# CITY OF ALBUQUERQUE

November 13, 2015

**RE: Multi-Specialty Clinic  
Grading and Drainage Plan & Drainage Report  
Engineer's Stamp Date 9-16-15 (File: M15D026B)**

JOEL D. HERNANDEZ P.E. #17893	ENGINEER'S SEAL	MULTI-SPECIALTY CLINIC 2901 TRANSPORT ST. S.E.	DRAWN BY DY
		GRADING AND DRAINAGE PLAN	DATE 11/06/15
		TIERRA WEST, LLC 5571 MIDWAY PARK PLACE NE ALBUQUERQUE, NM 87109 (505) 858-3100 www.tierrawestllc.com	2015044-GRB
			SHEET # GR-3
			JOB # 2015044

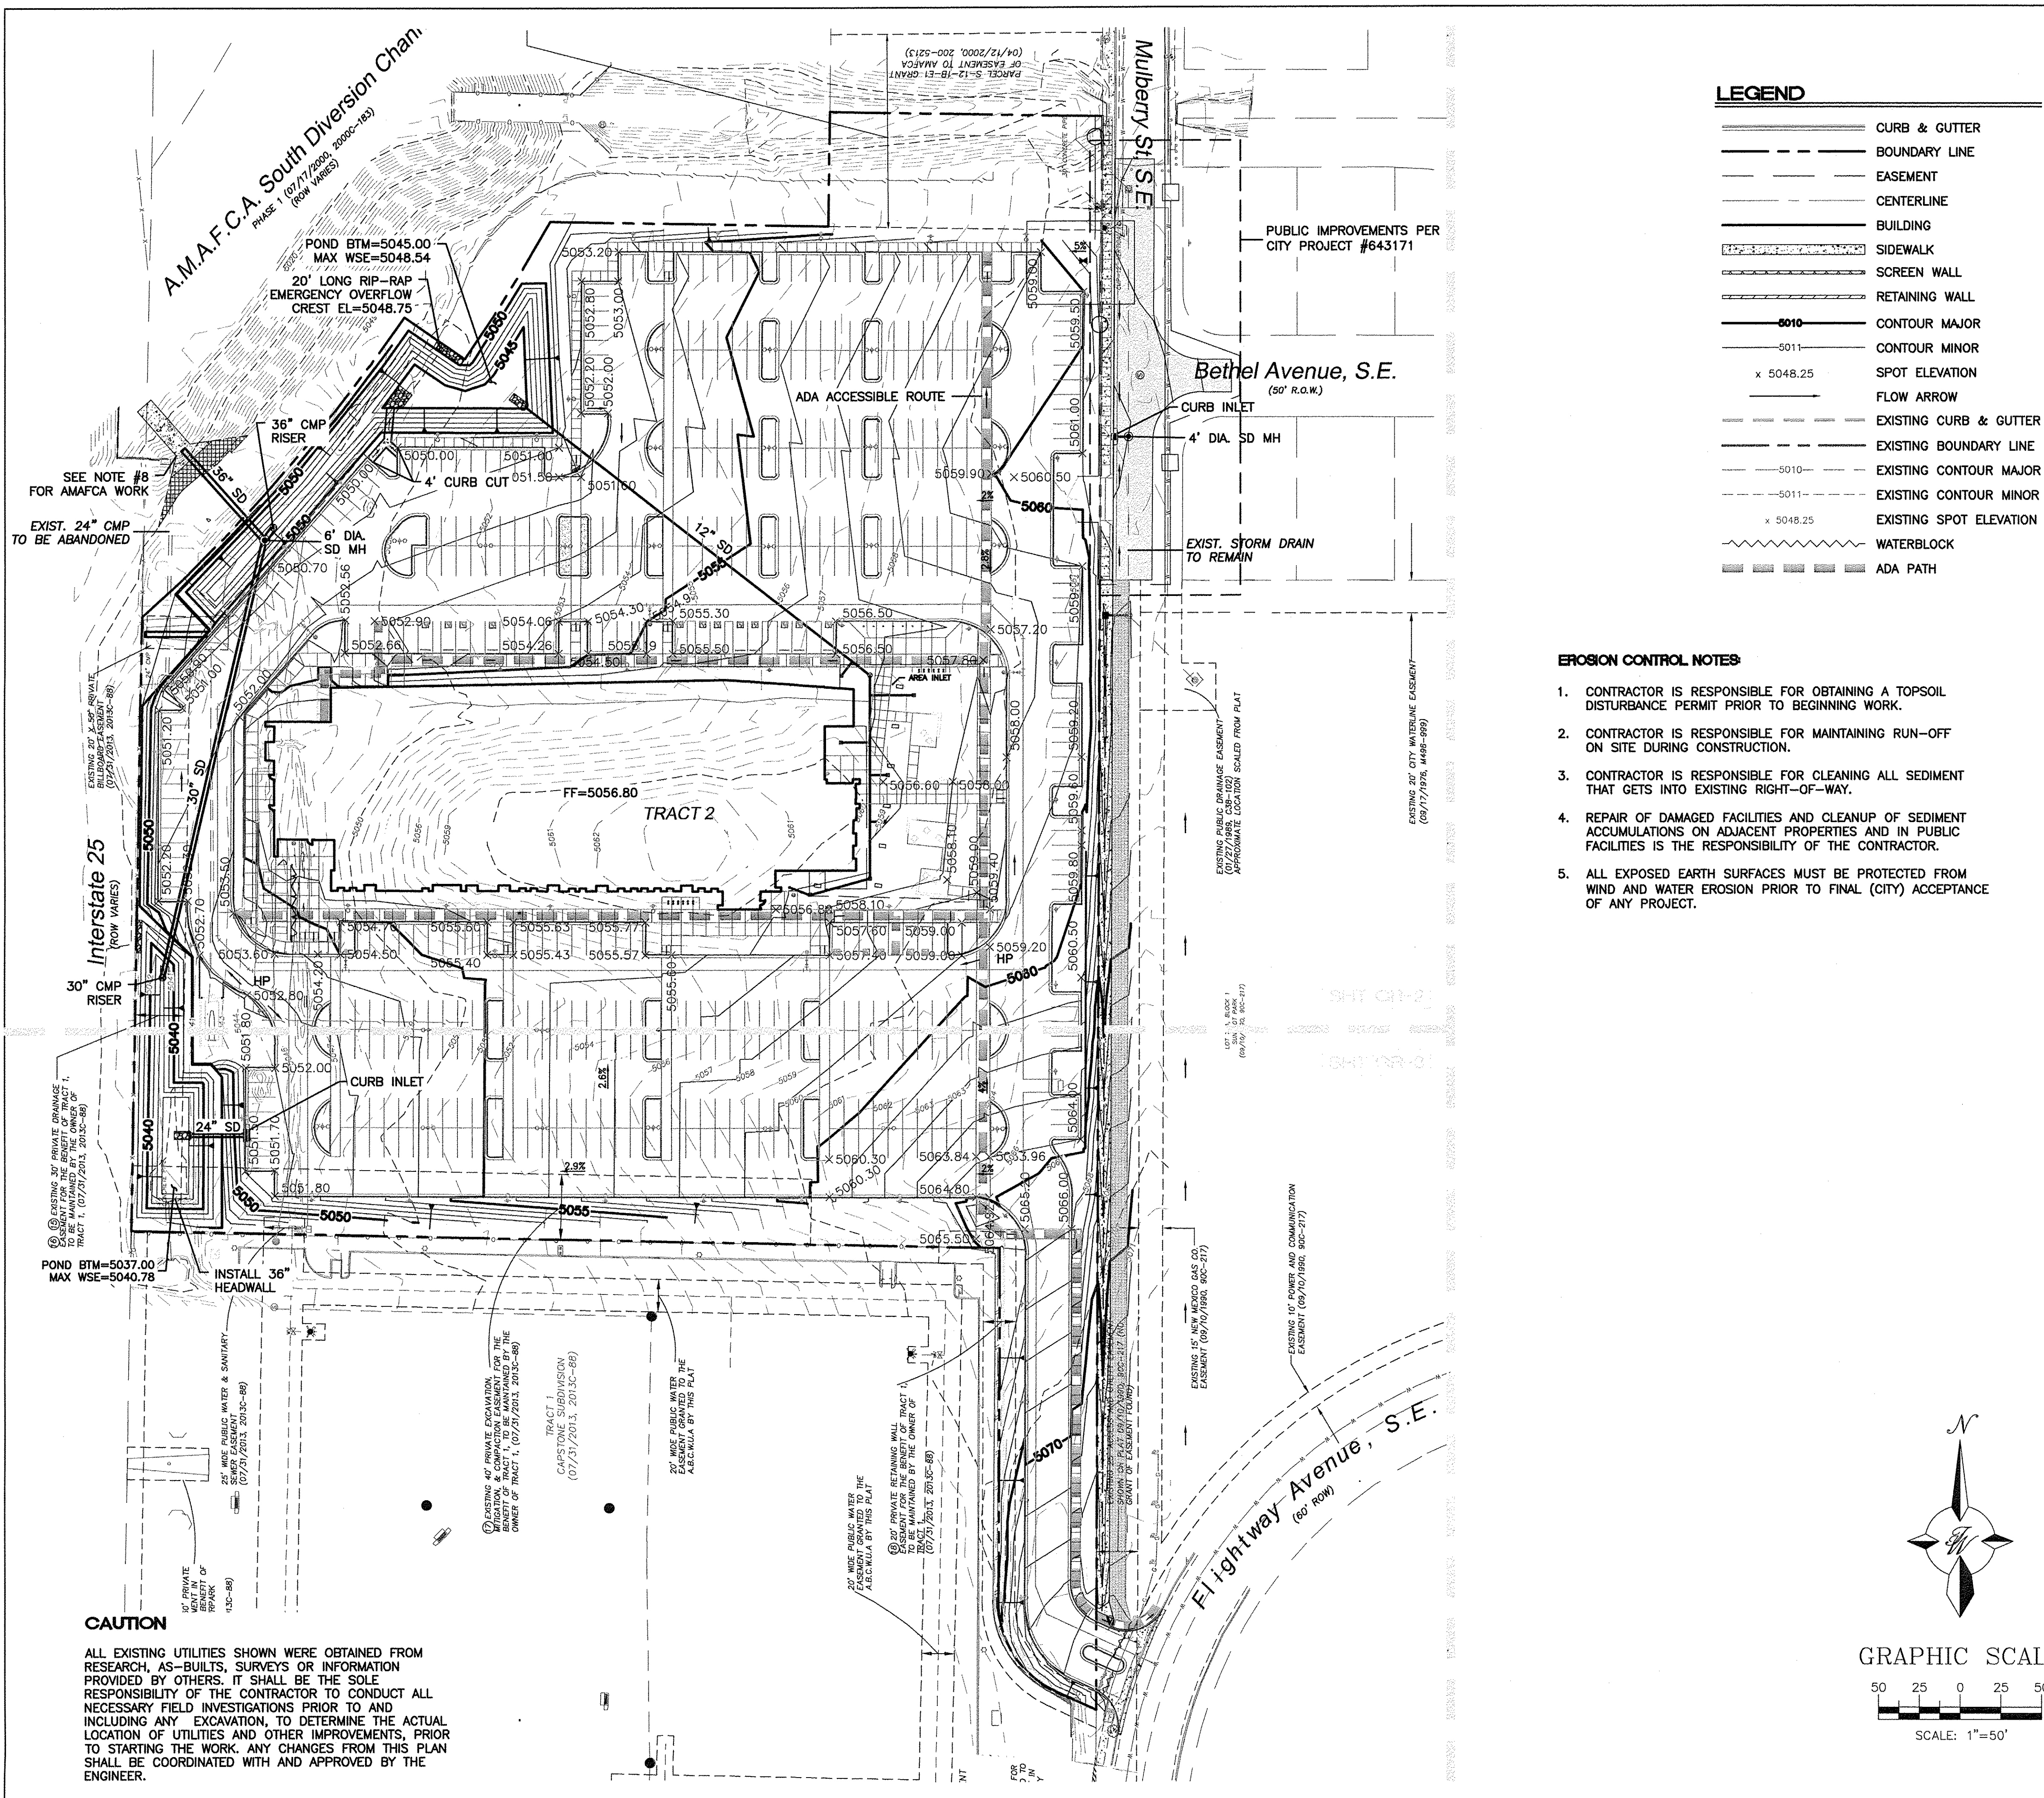
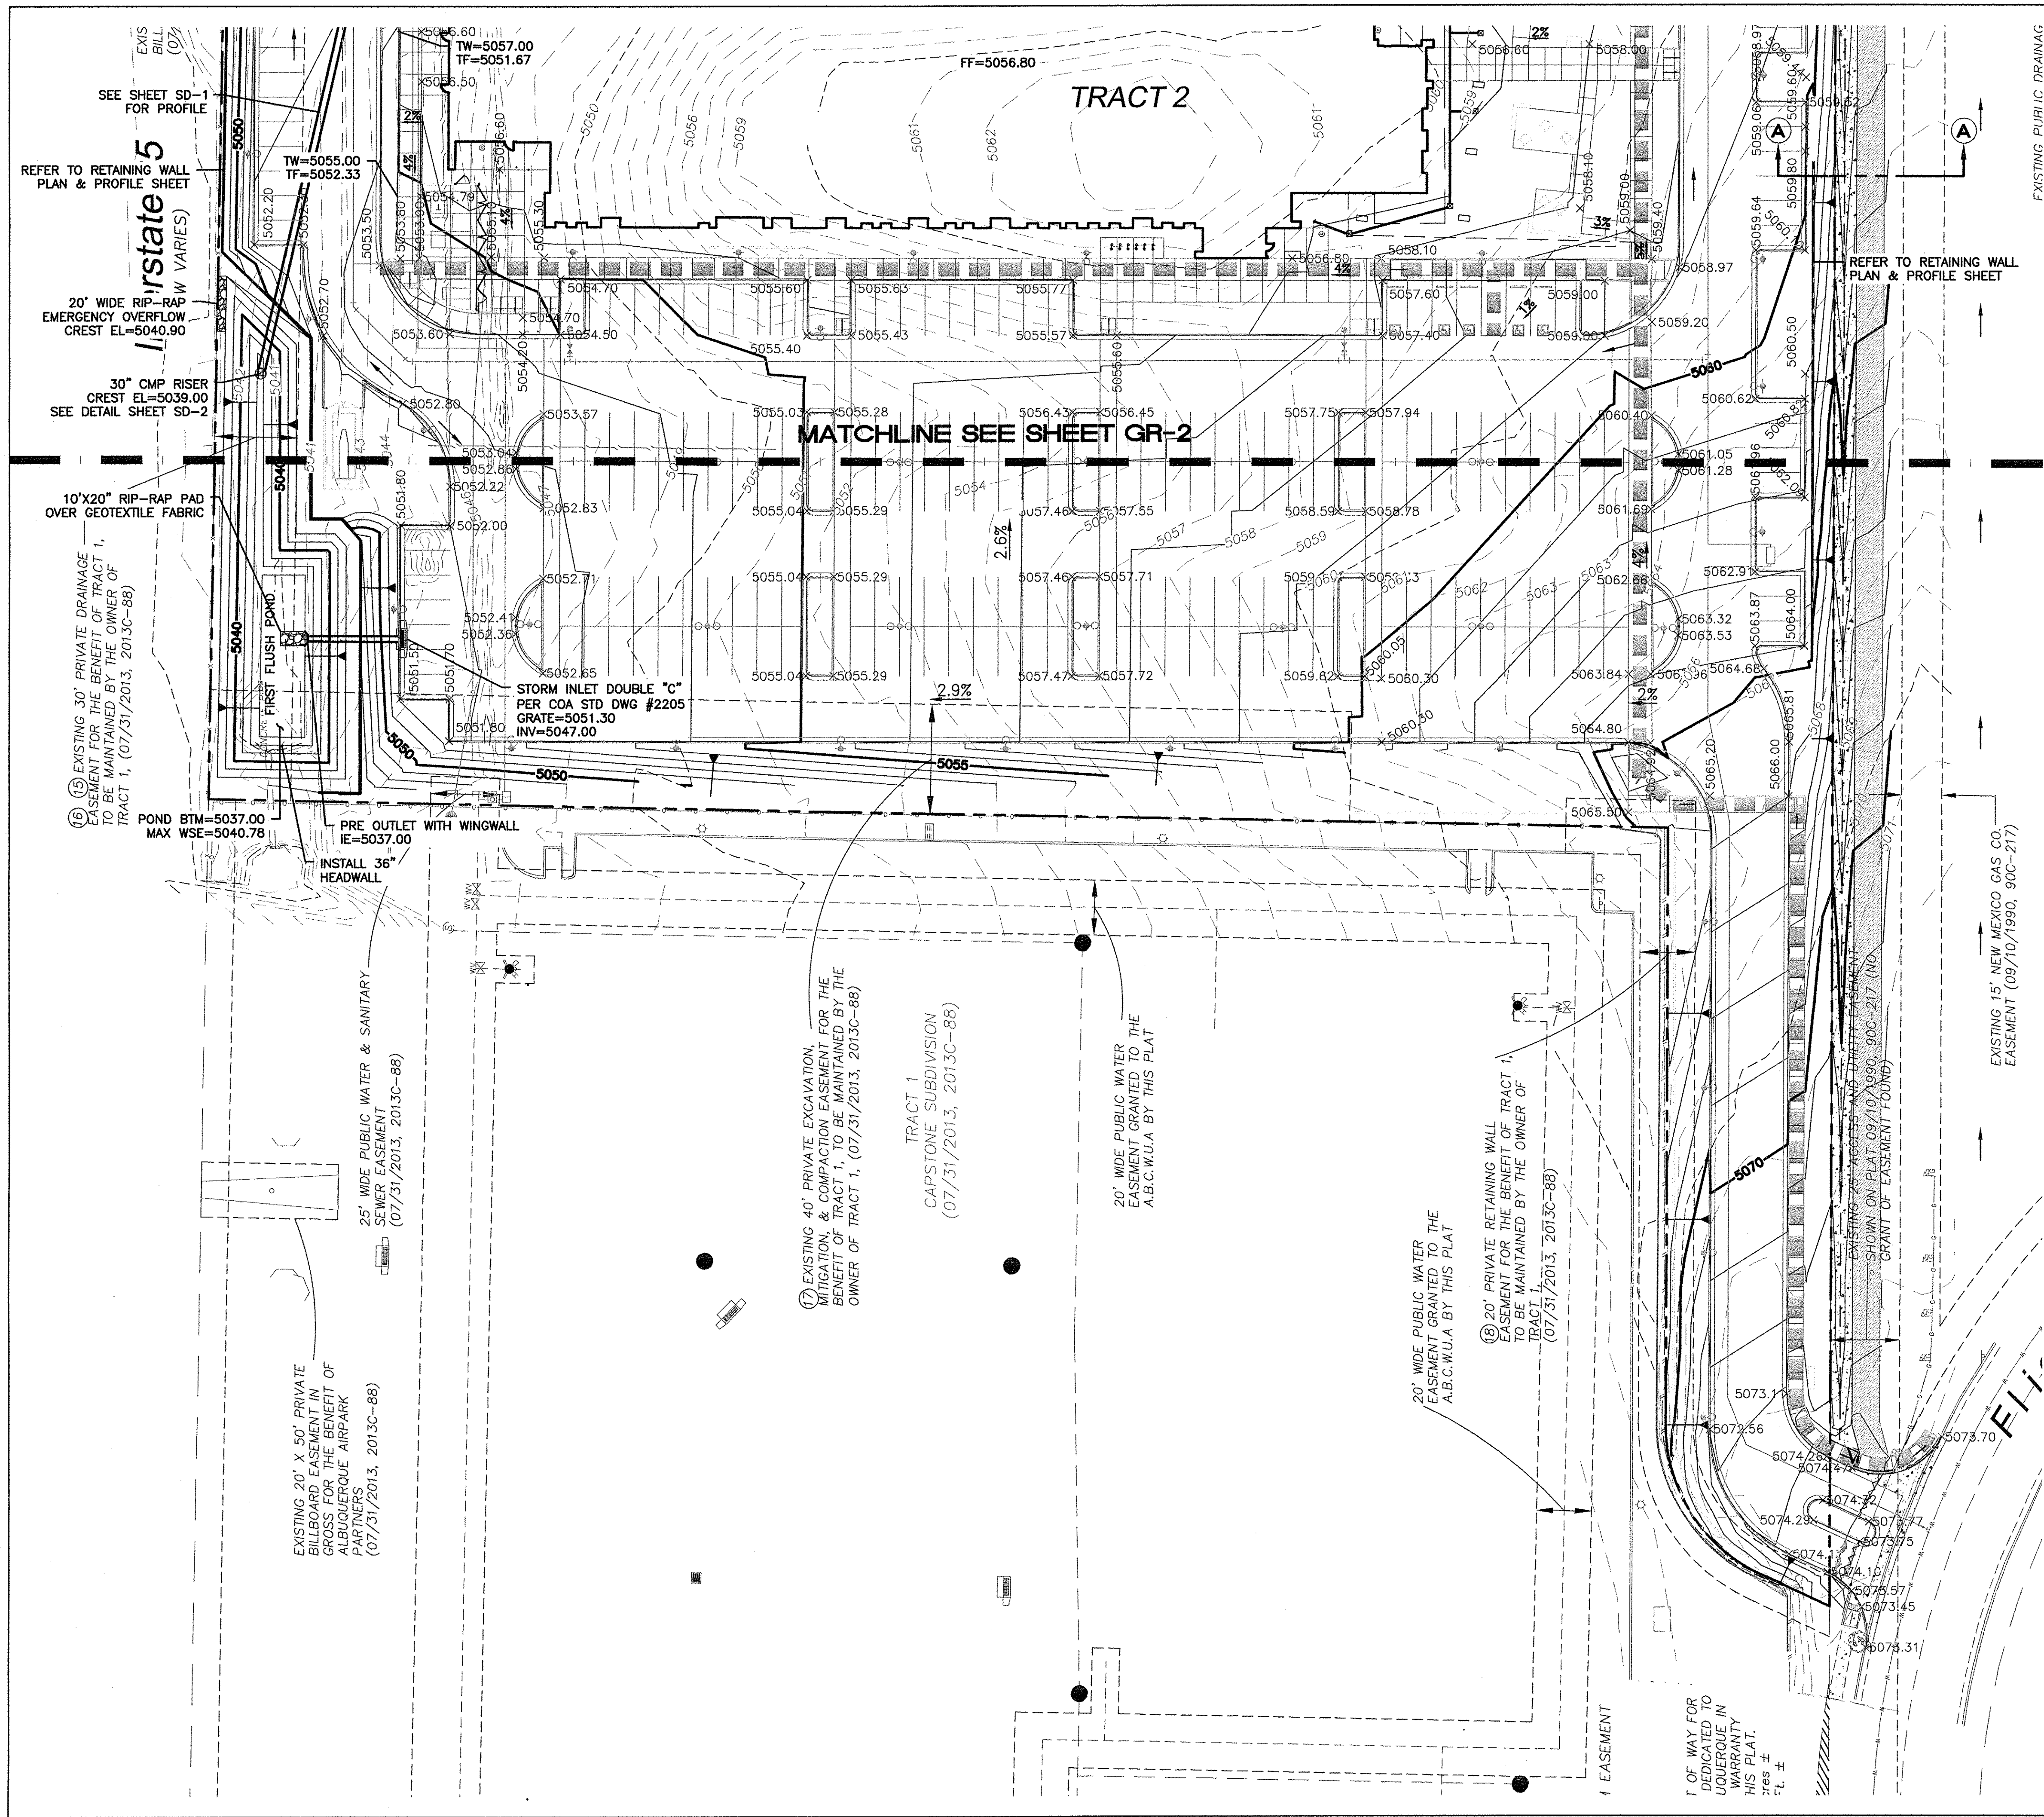
5. The grading plan does not appear to account for the construction of some of the ADA ramps, for example, Sheet GR-3, shows untied/conflicting contour line work and does not appear to give the contractor enough information to build the ramps correctly in the vicinity of the retaining wall. Elevations shown for the ramp will likely not work with the header curb dimensions suggested on the Site Plan.

Profile - 2 - Base

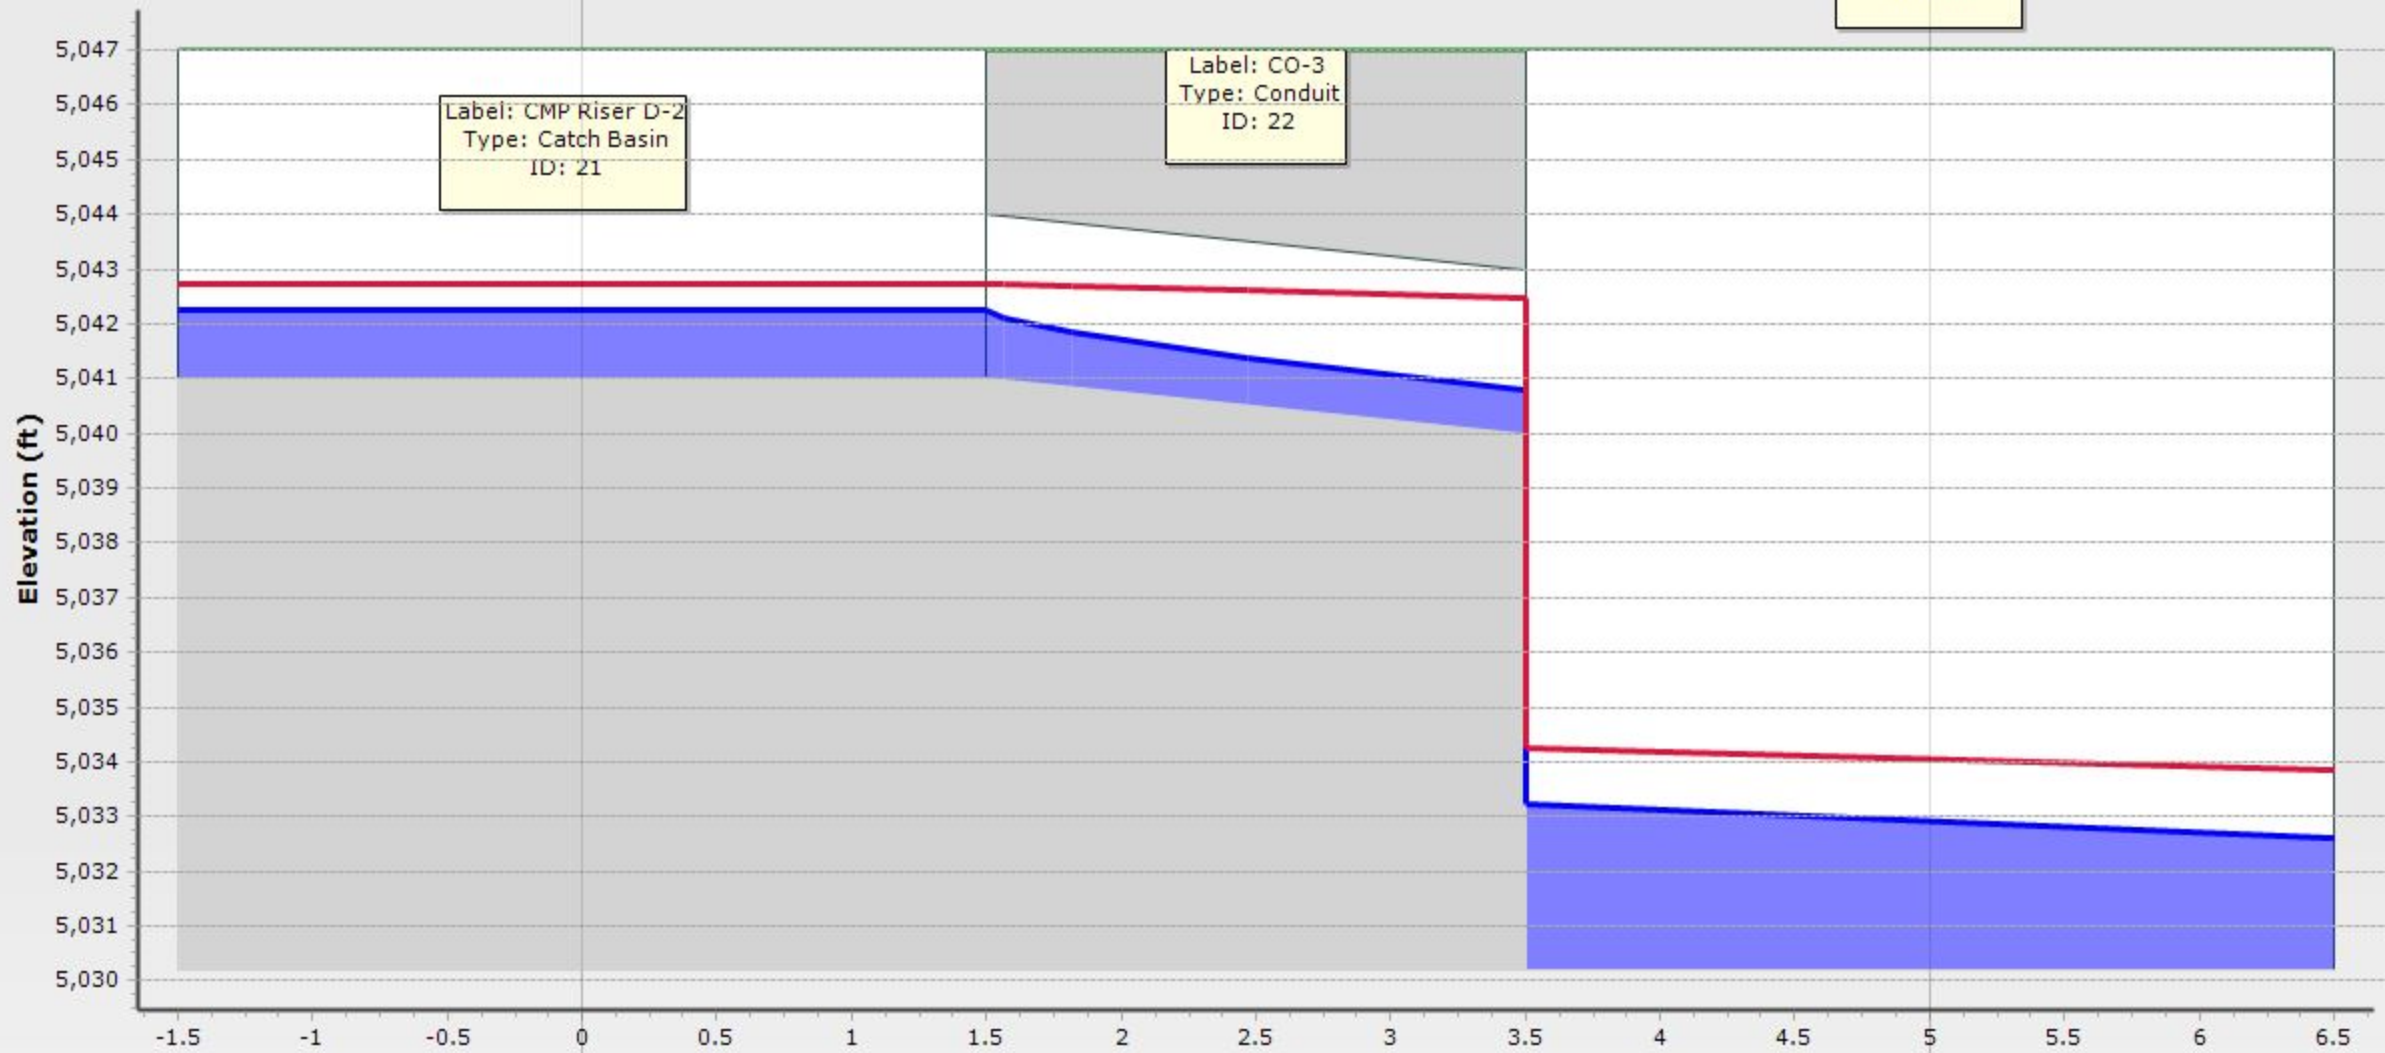
8. Show the pipe connection from Phase I as an existing structure to be preserved (or show new outlet structure/improvements if that is the intent).
9. Reprint the StormCAD output for "Profile-2" (pipe CO-3), it is not legible in the report.
